Development Control
Ribbles Valley Borough Council

App no: 24.0405

Address: Bowland Forest Farm Settle Road Bolton By Bowland

Proposal: Proposed redevelopment of part of the site to extend the existing cafe, create farm shop together with a single storey extension to incorporate food prep area, storeroom and plant room. Creation of car parking, new access, landscaping and associated works (pursuant to the removal of condition 8 (reinstate footway and verge to full kerb height) of planning permission 3/2023/0775)

Title: Bowland Forest Farm
Refuse Layby Detail

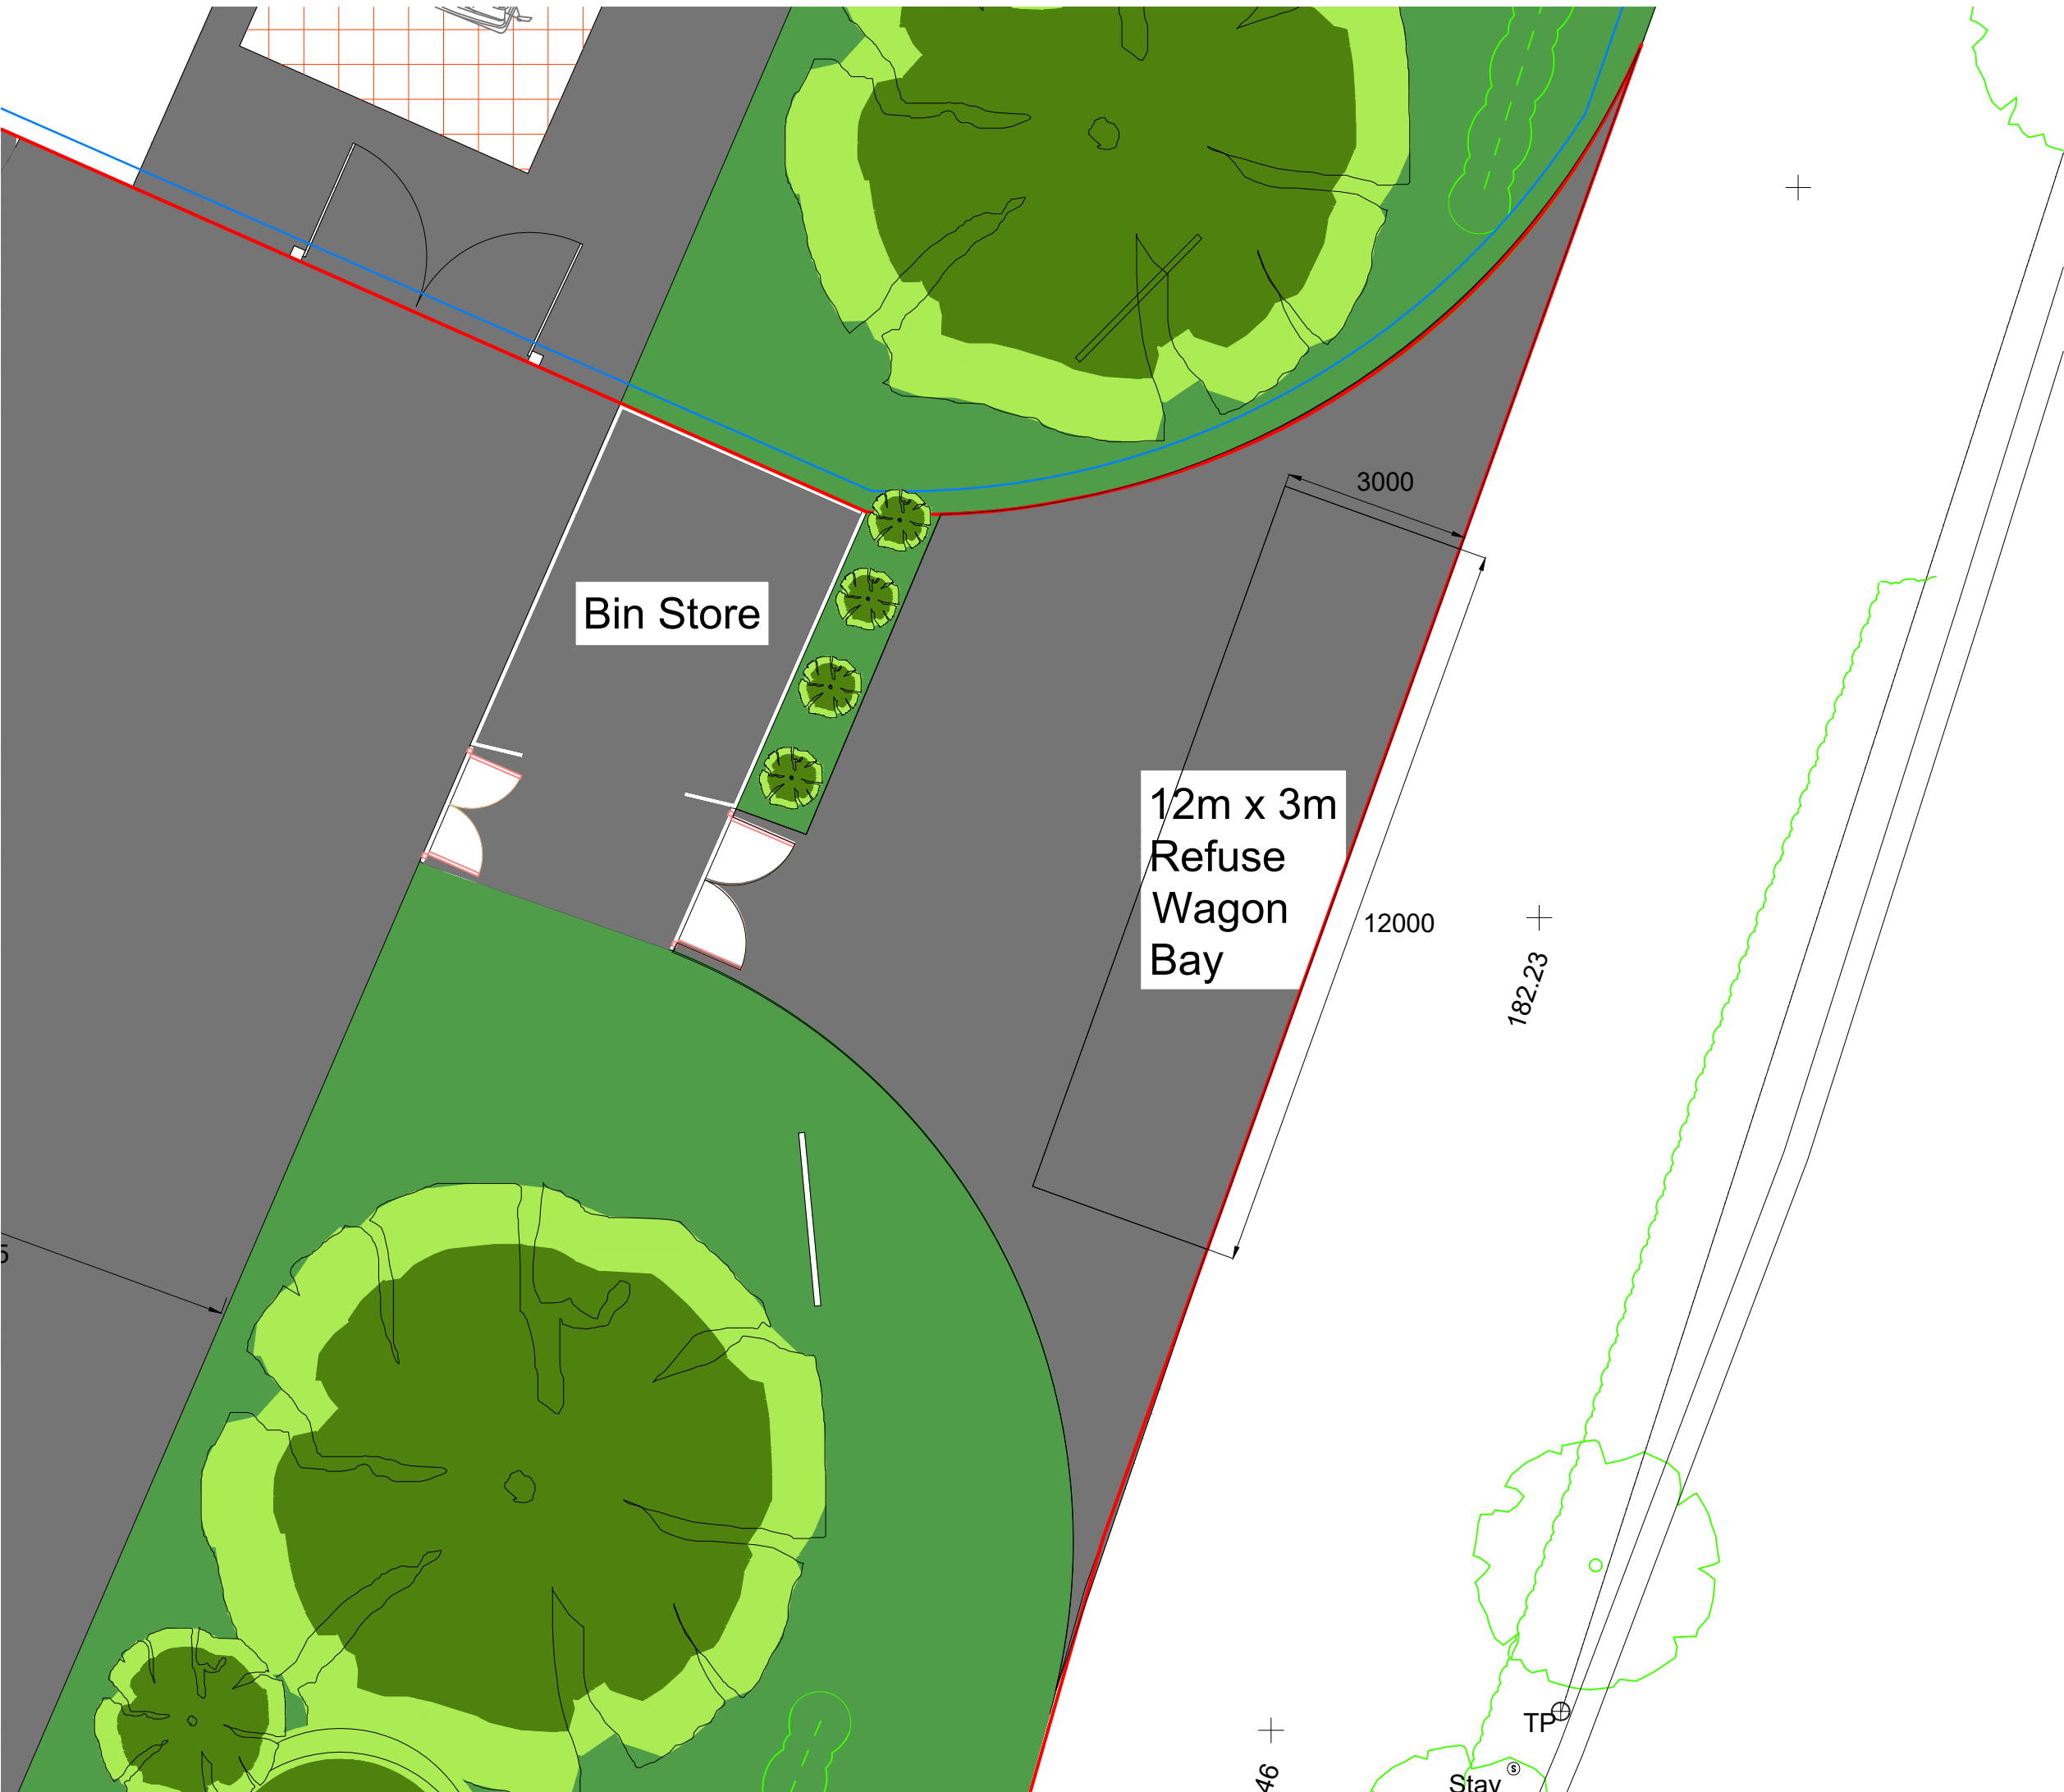
The applicant has sought confirmation from Ribble Valley BC Refuse Collection Team that the layby is beneficial for the refuse service and that they would support its retention.

There is no objection to this and therefore we would raise no objection to the removal of condition 8.
